# **OXFORDSHIRE COUNTY COUNCIL'S RESPONSE TO CONSULTATION ON THE FOLLOWING DEVELOPMENT PROPOSAL**

**Application no:** 16/01000/F-2

**Proposal:** Development of the Village Centre (south) comprising a Hotel and associated facilities (involving the partial demolition and the refurbishment and extension of Building 455 and its change of use); Bar/Brasserie (involving the partial demolition and refurbishment and extension of Building 457) and a Covered Market (canopy link between Buildings 455 and 457) with associated landscaping and car parking.

**Location:** Building 455 And 457 Heyford Park Camp Road Upper Heyford

TITLE: UPPER HEYFORD  
 DETAILS: VILLAGE CENTRE  
 CAR AND DELIVERY TRACKING SHEET 2

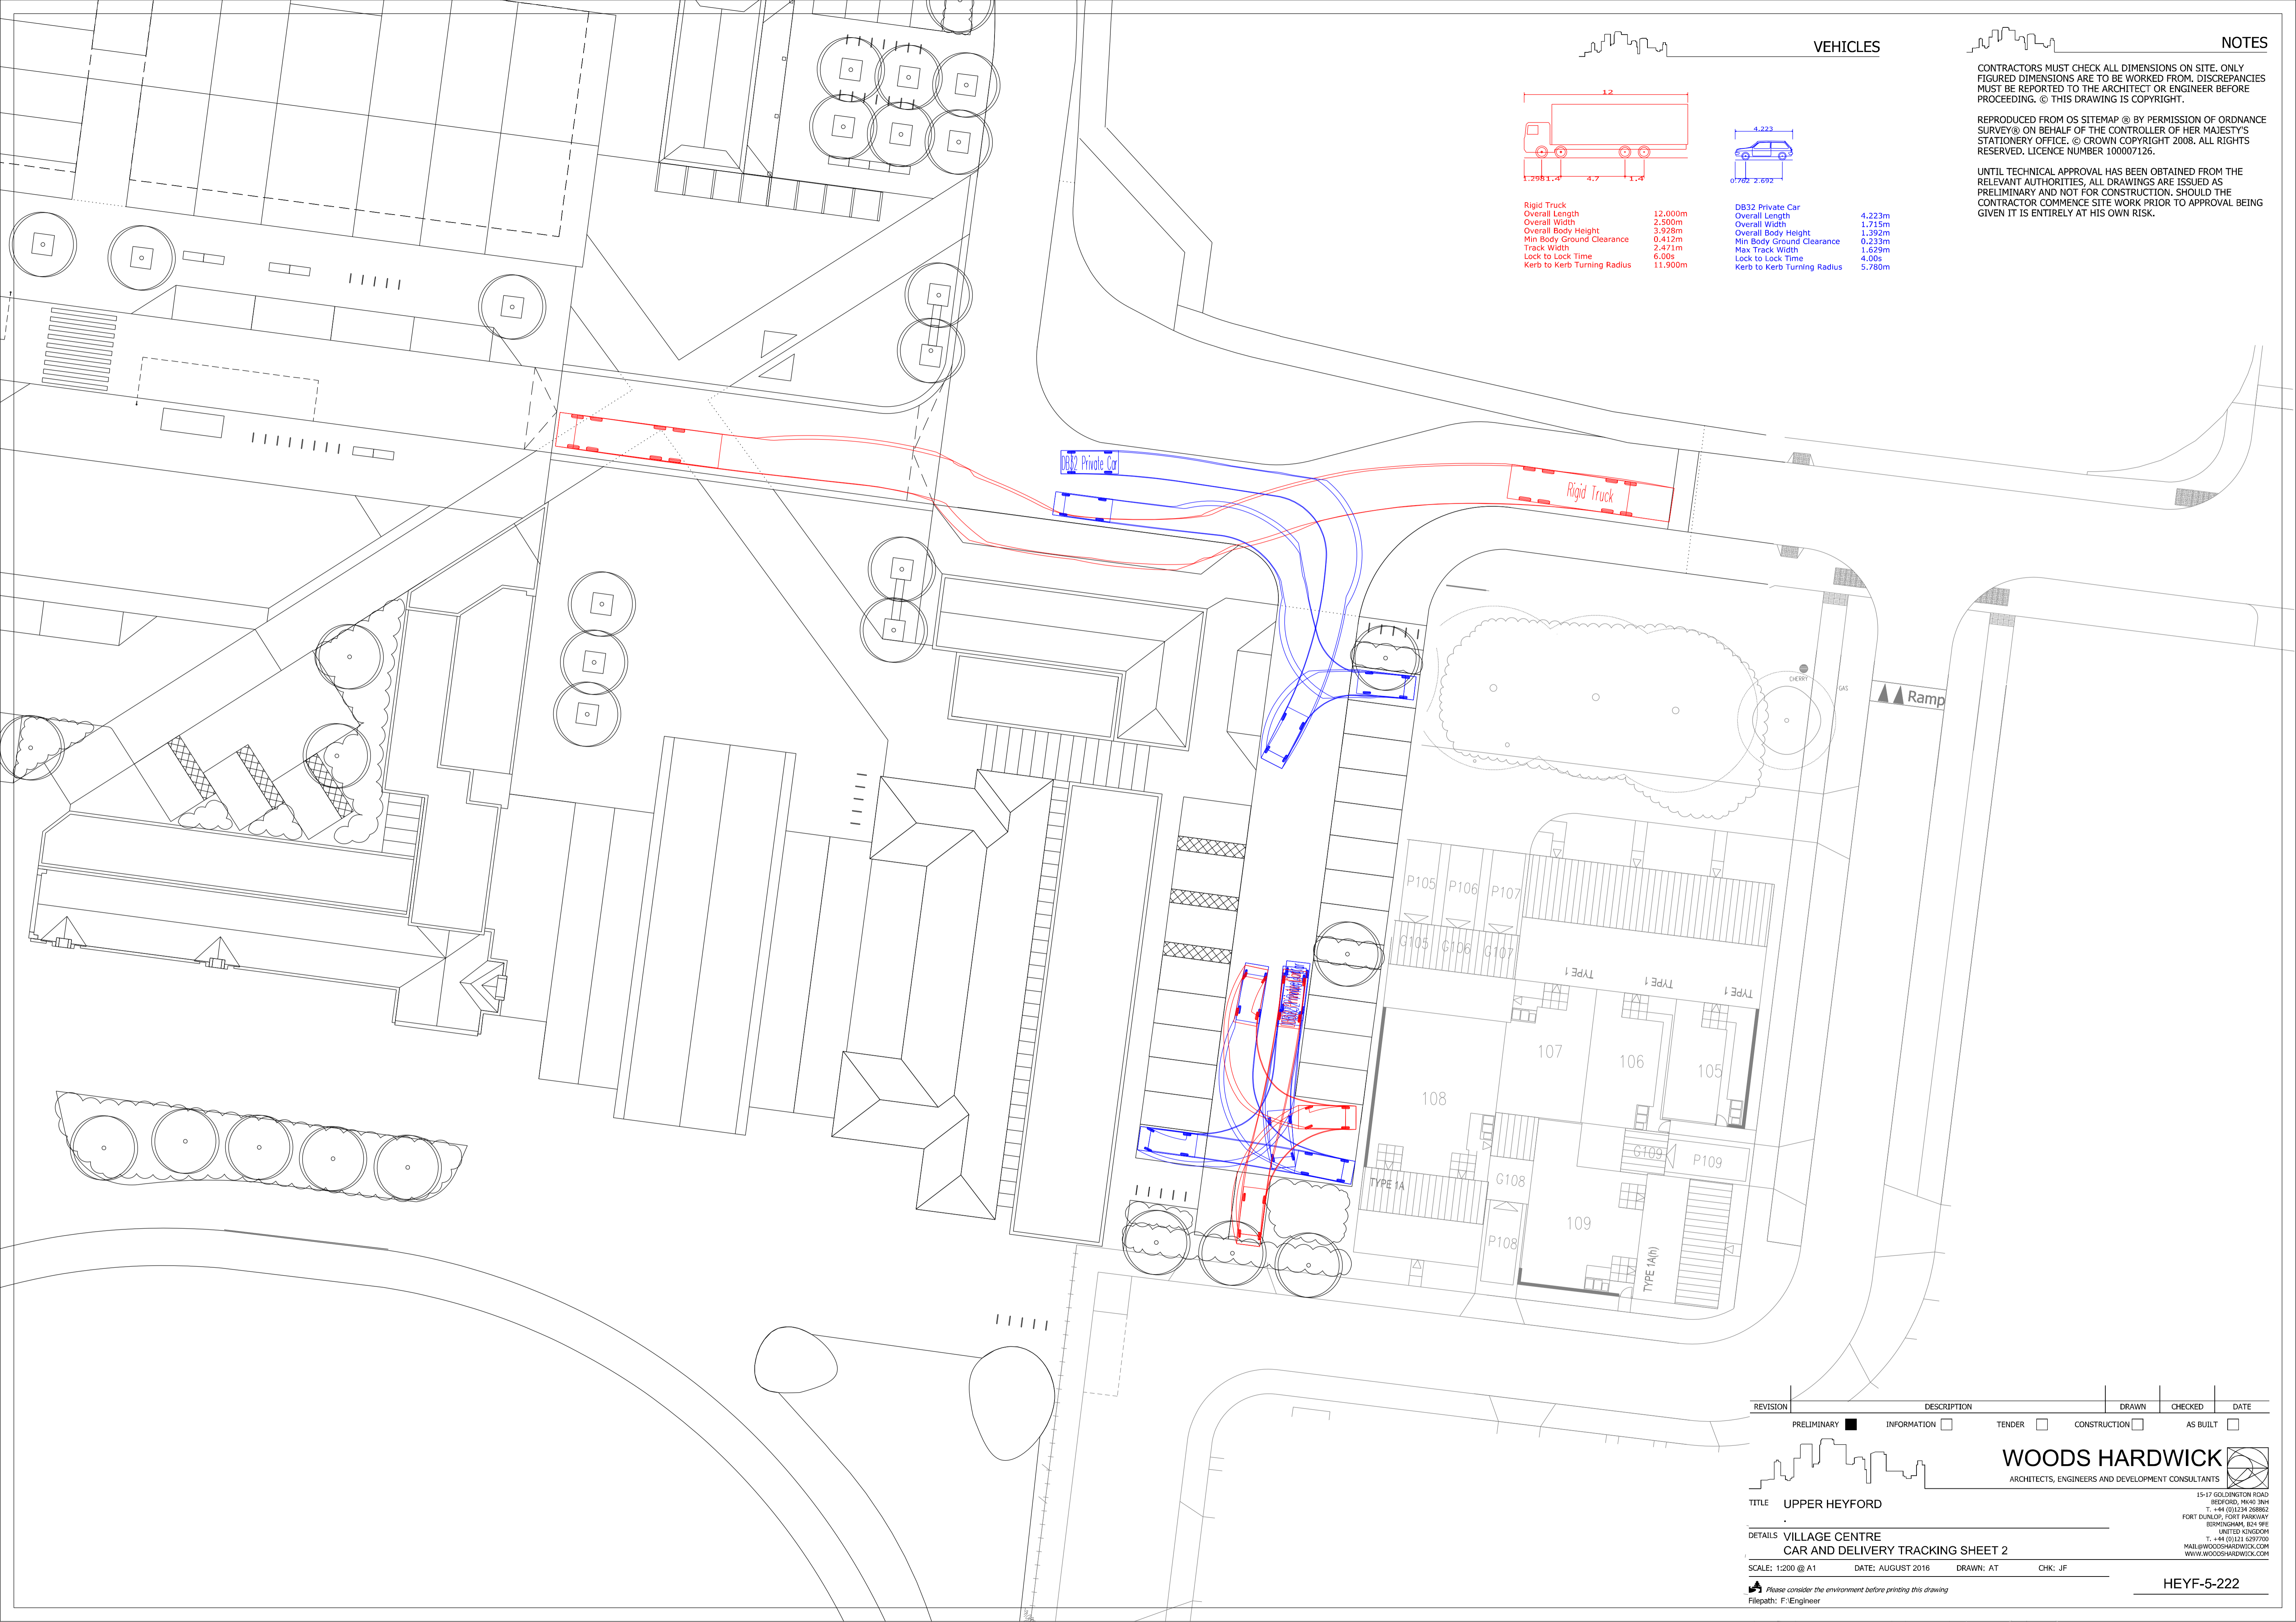
- Delivery bay on the western access road is not wide enough – this shows clearly in the tracking drawing supplied. This needs to be addressed
- Delivery to the hotel building is highly unlikely to be made from the delivery bay on Camp Road. The hotel would want deliveries to be made to the back entrance, direct to the kitchen area, and as a result, I think vans would reverse down the car park which would be unsafe. This needs to be addressed, to show suitable delivery arrangements to the rear of the building.
